TfNSW Reference: SYD21/00188/14

DPE's Reference: SSD-14378717

**UPDATED RESPONSE TO SUBMISSIONS FOR STAGE 1A TELOPEA  
ADDERTON ROAD, TELOPEA**

TELOPEA URBAN RENEWAL PROJECT
MASTERPLAN
INTERSECTION PLAN
SHEET 3

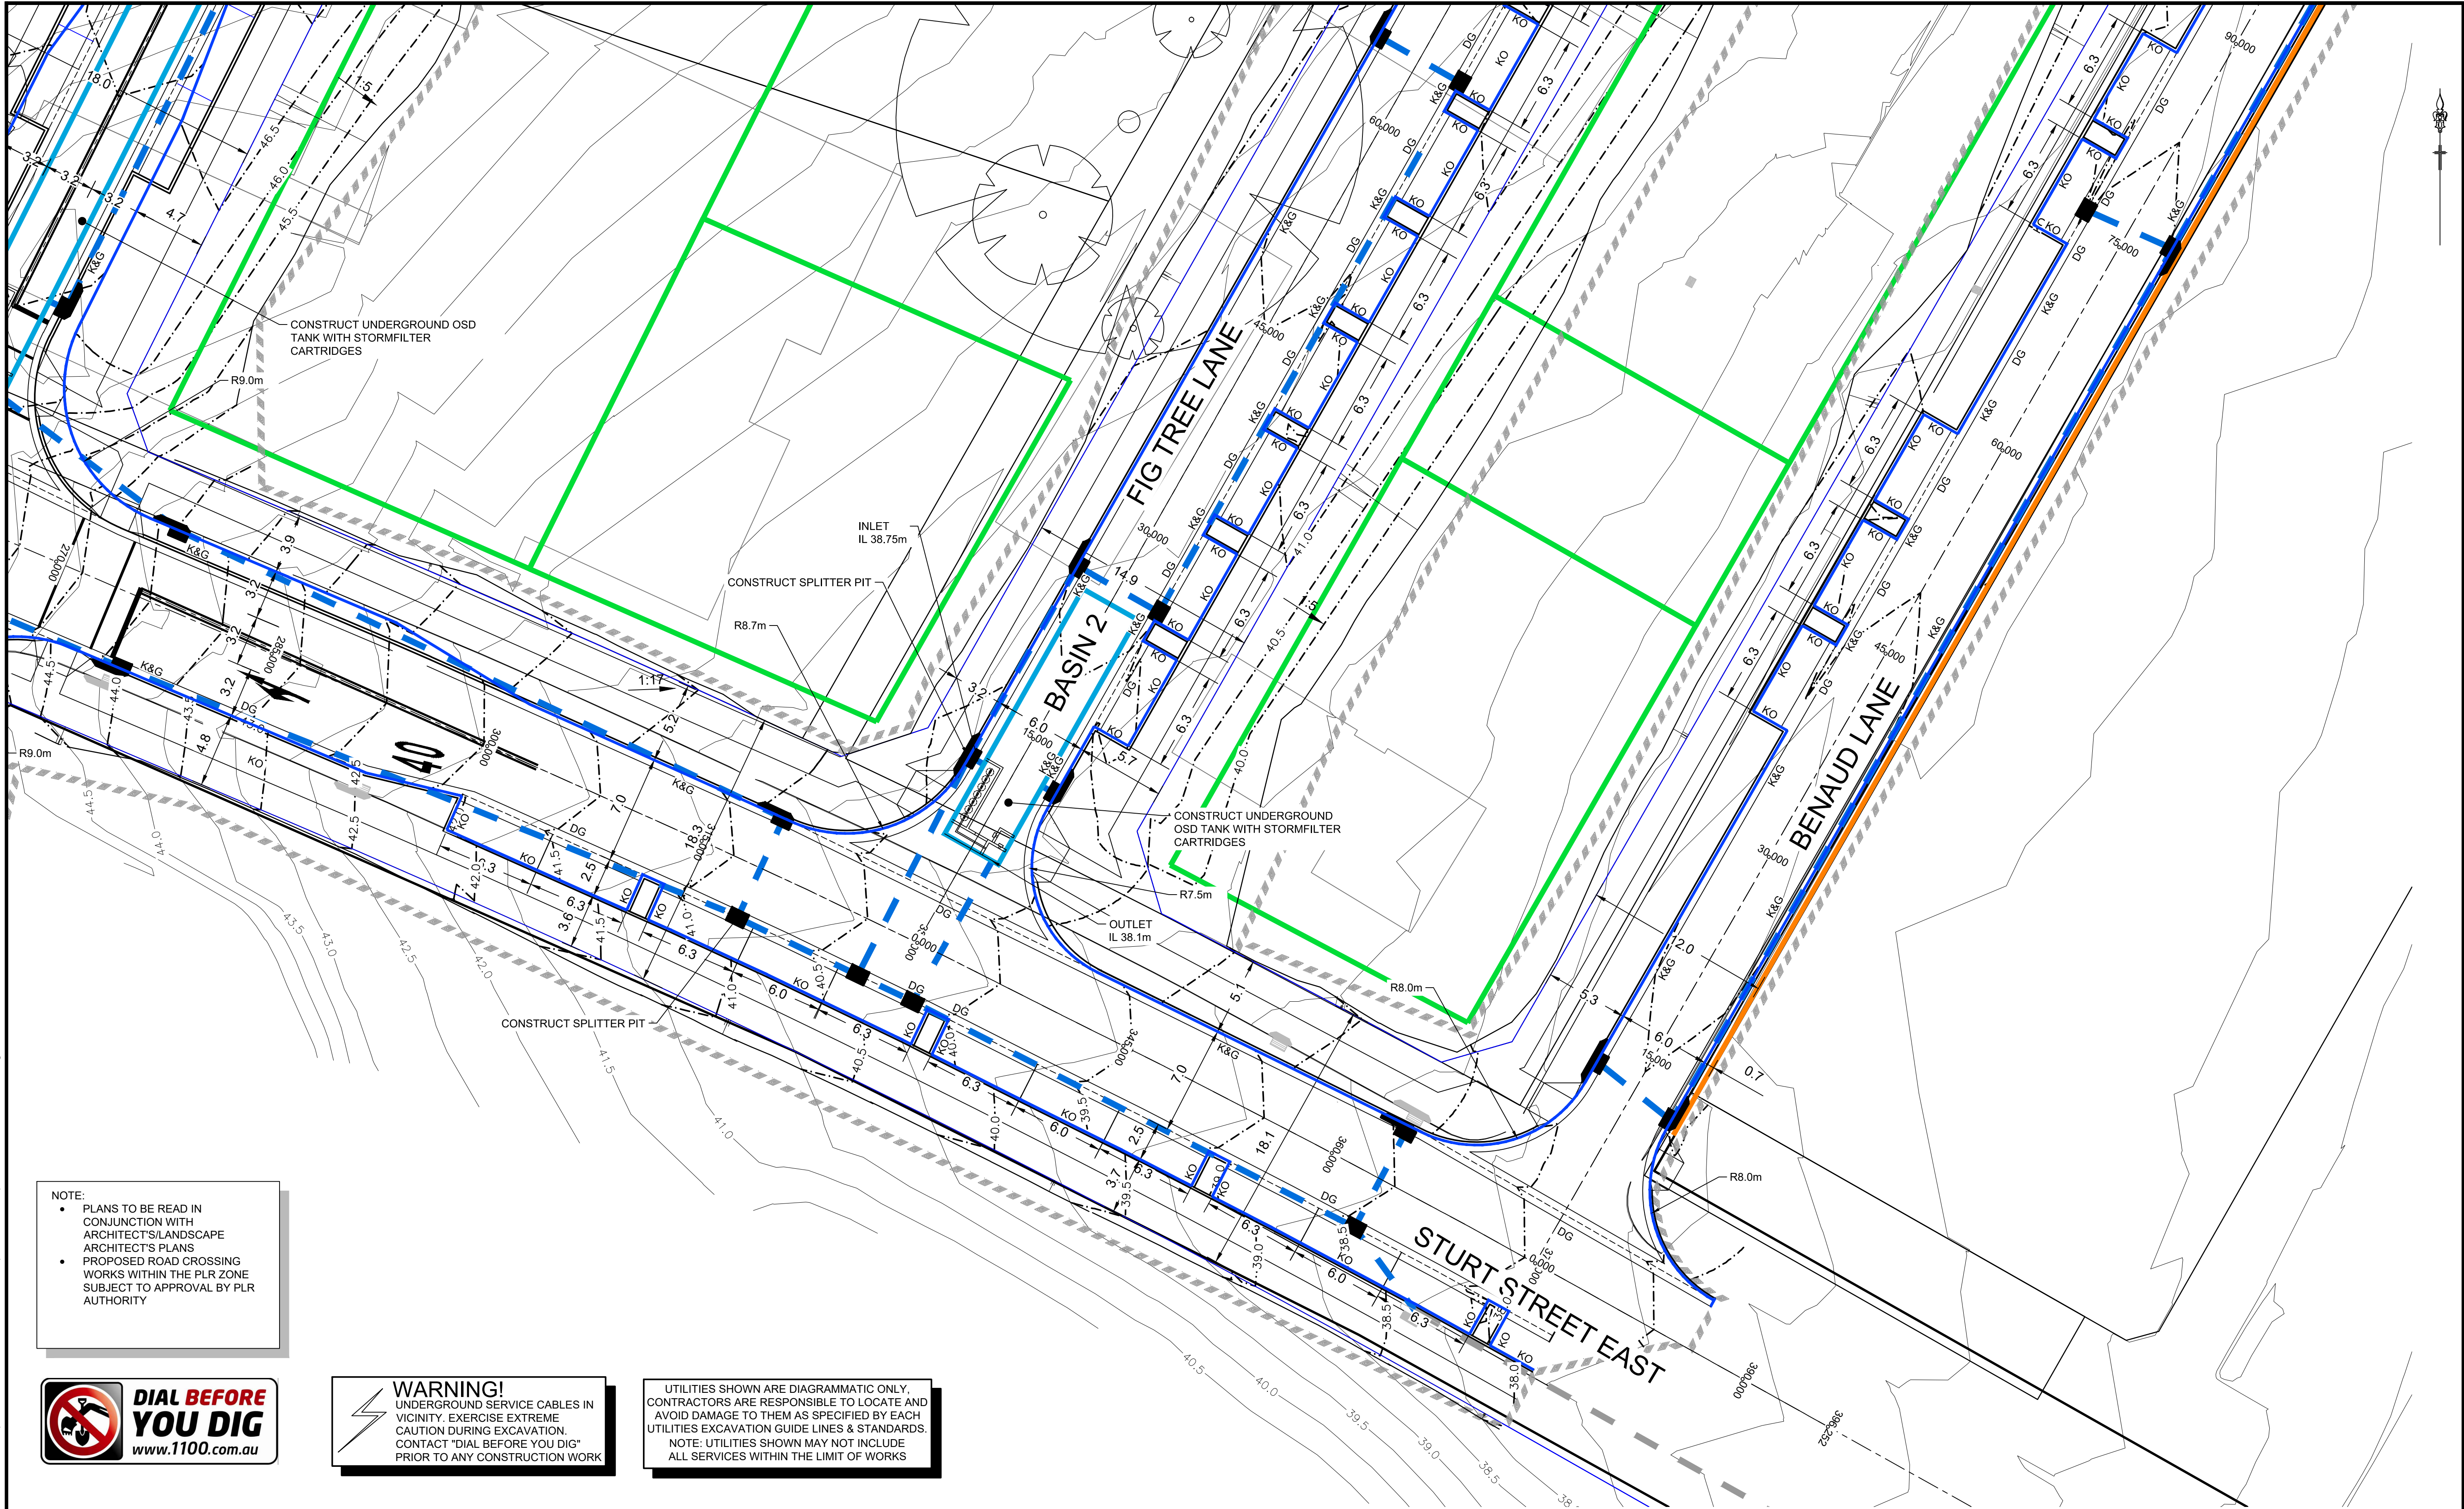
TfNSW requires the pedestrian refuge island to be relocated further to the east along Sturt Street East, to encourage pedestrian use of the signalised crossing facility at Adderton Road/New Link Road that is a safer desire line.

TfNSW raises safety concerns regarding the right turn bay into Sturt Street North, due to proximity to Adderton Road. Westbound motorists may assume the right turn bay services Adderton Road and may mistakenly enter. This will create weaving movements that increase the chance of lane change and rear end type crashes.
